Rezoning Transportation Analysis
Petition Number: Insert Zoning Petition #2021-025
General Location Identifier: Tax ID 16511318

Revision Log:	Date	Description
	02-25-21	First Review (LJ)
	03-25-21	Second Review (WB)

The site is located on Wallace Lane (City-maintained, Local Street). The site is in the East Wedge and the South East Corridor and is outside Route 4. Applicable area plans include the Independence Boulevard Plan.

RZ-1.0

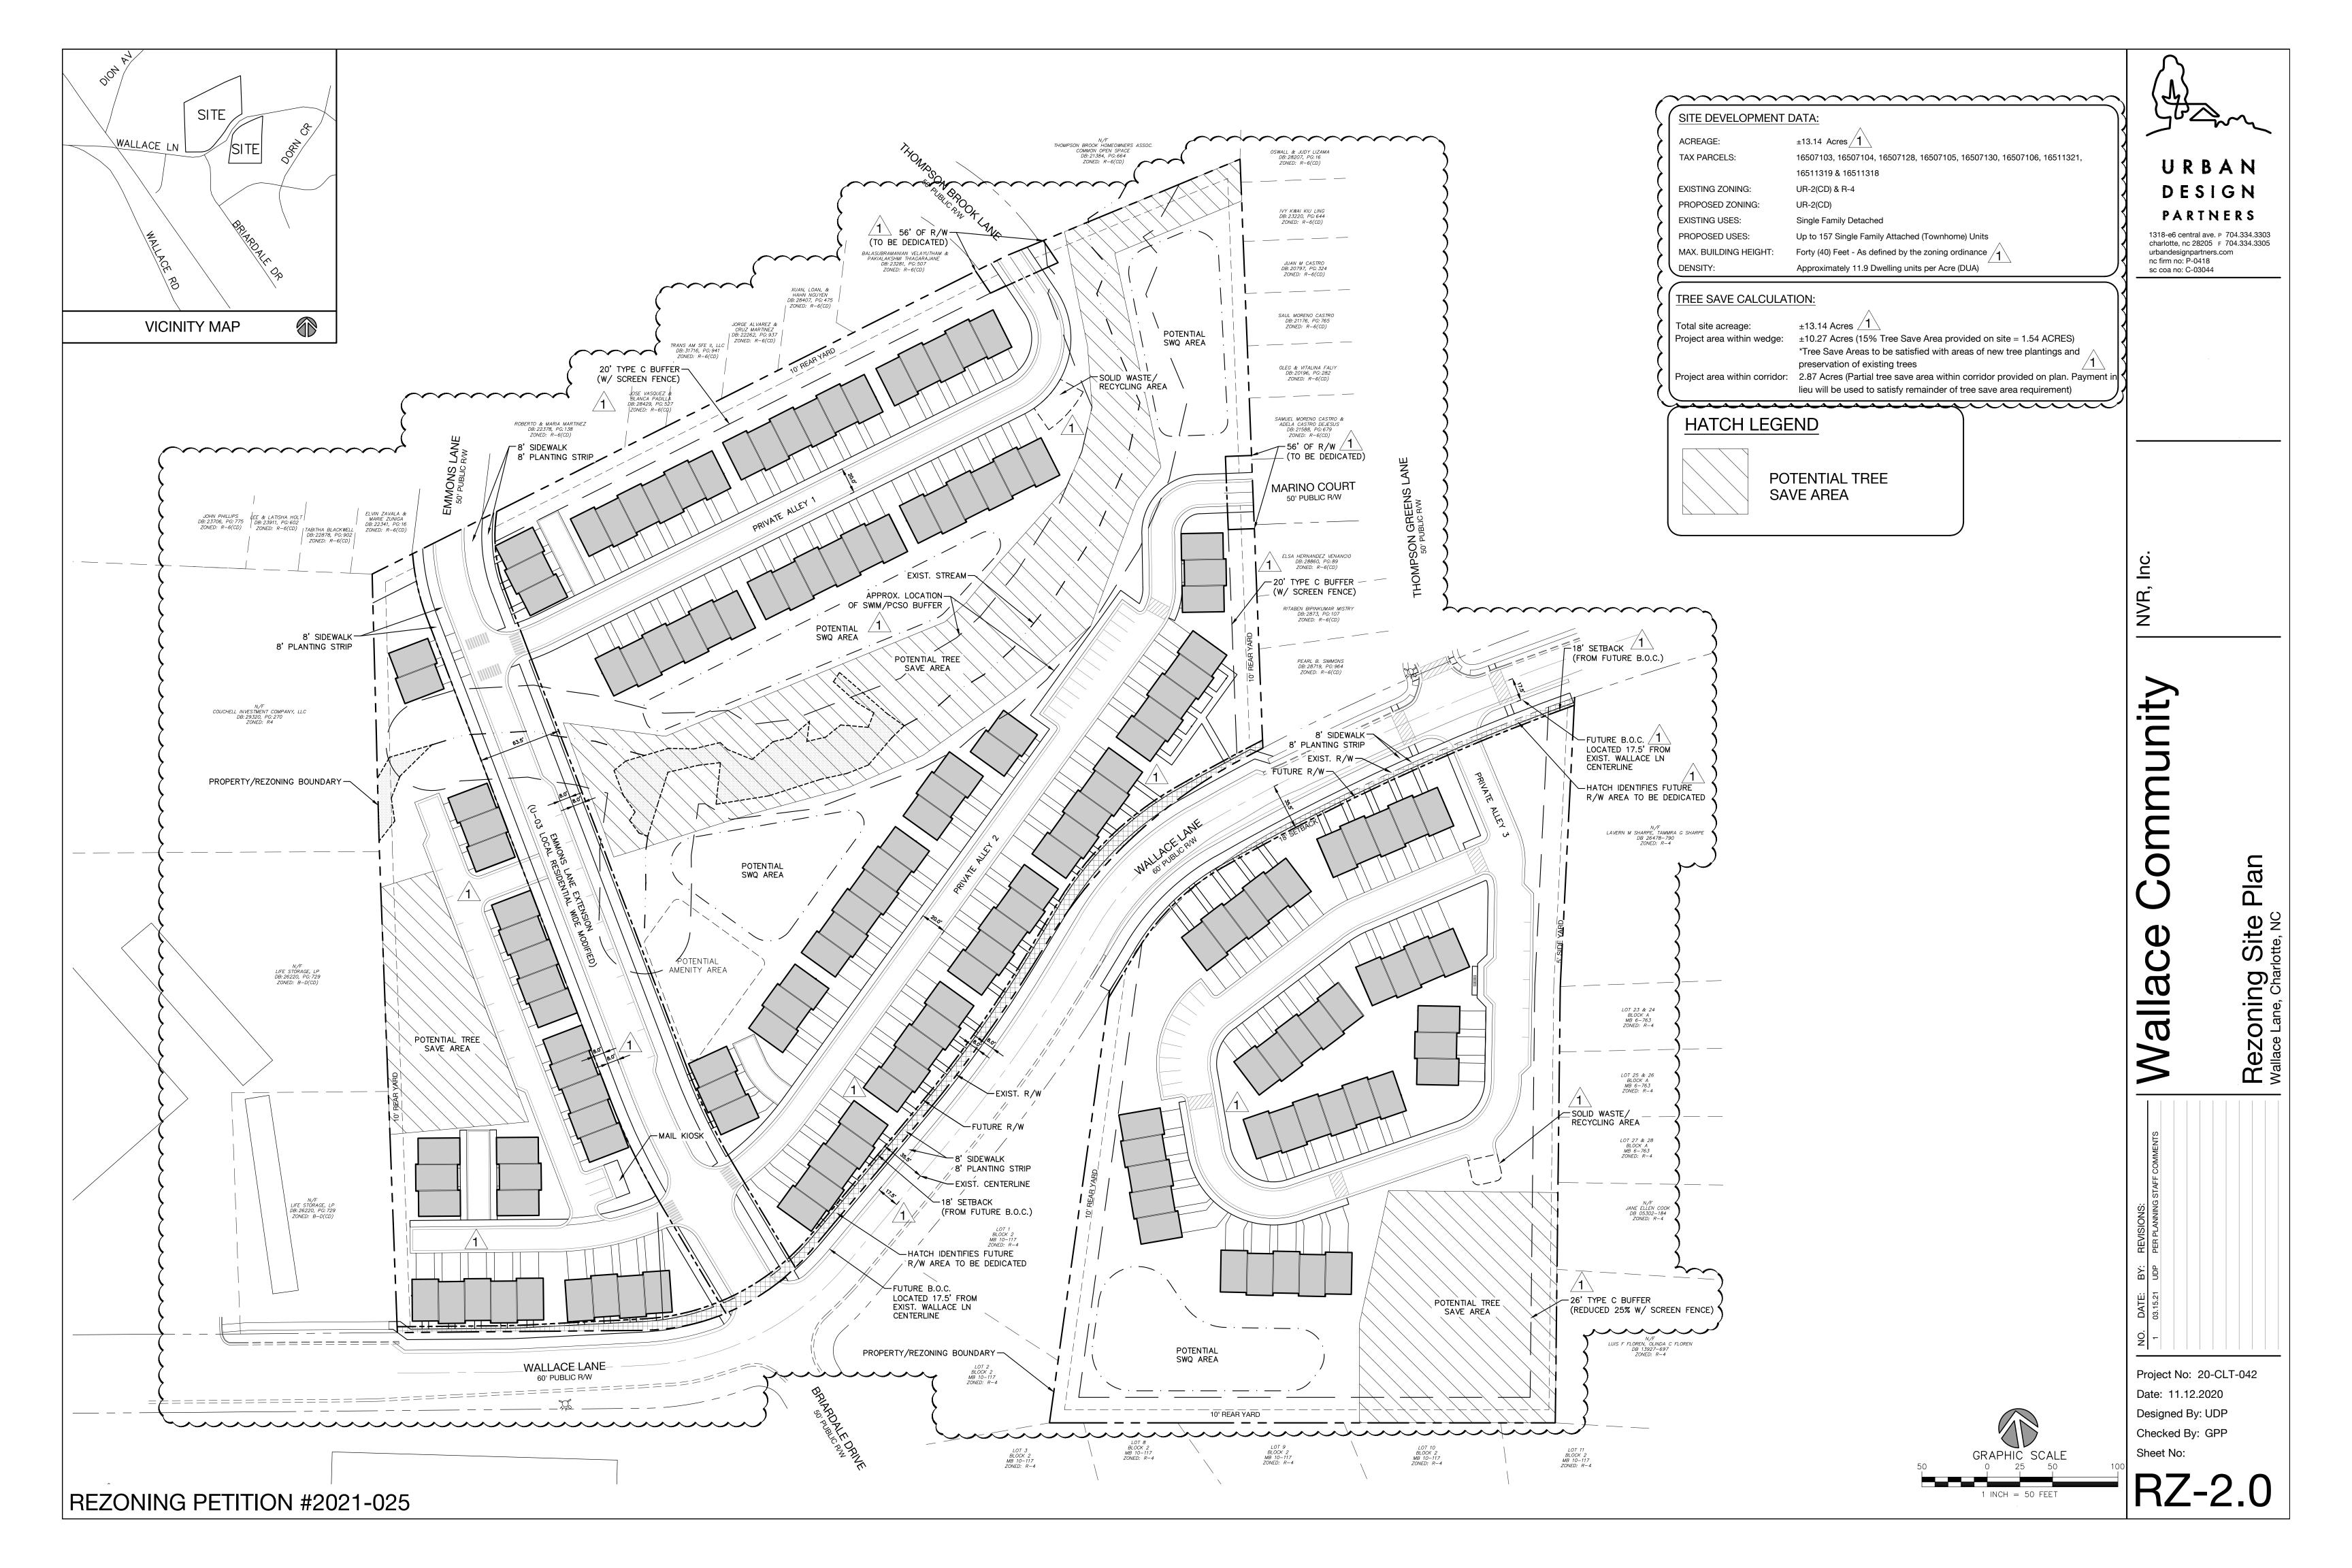
4. **OUTSTANDING (03/18/2021):** ~~Revise site plan and conditional note(s) to commit to construct an 8-foot planting strip, and 8-foot sidewalk on Wallace Lane and Emmon Lane extension per Chapter 19 / Chapter 20. The site plan shall label and dimension both items from the back of curb and gutter and road centerline. CDOT request of rights-of-way set at 2' behind back of sidewalk where feasible.~~

5. **OUTSTANDING (03/18/2021):** Revise site plan to provide for Private Alley 1 and Private Alley 2 to be private streets, as opposed to alleys, to allow for better connection to the existing public road street stubs

7. **New Comment (03/25/2021):** Revise site plan and conditional note(s) to commit to constructing left turn lanes into the development per CDOT standards for developments that generate more than 500 trips a day.

8. **New Comment (03/25/2021):** Revise site plan to demonstrate adequate Intersection Sight Distance (ISD) at all proposed public street connections to existing Wallace Lane per CDOT Sight Distance Policy and to ensure safe ingress and egress into the development. ISD must be shown in both horizontal and vertical dimensions (plan/profile) along the sight line, not the roadway centerline.
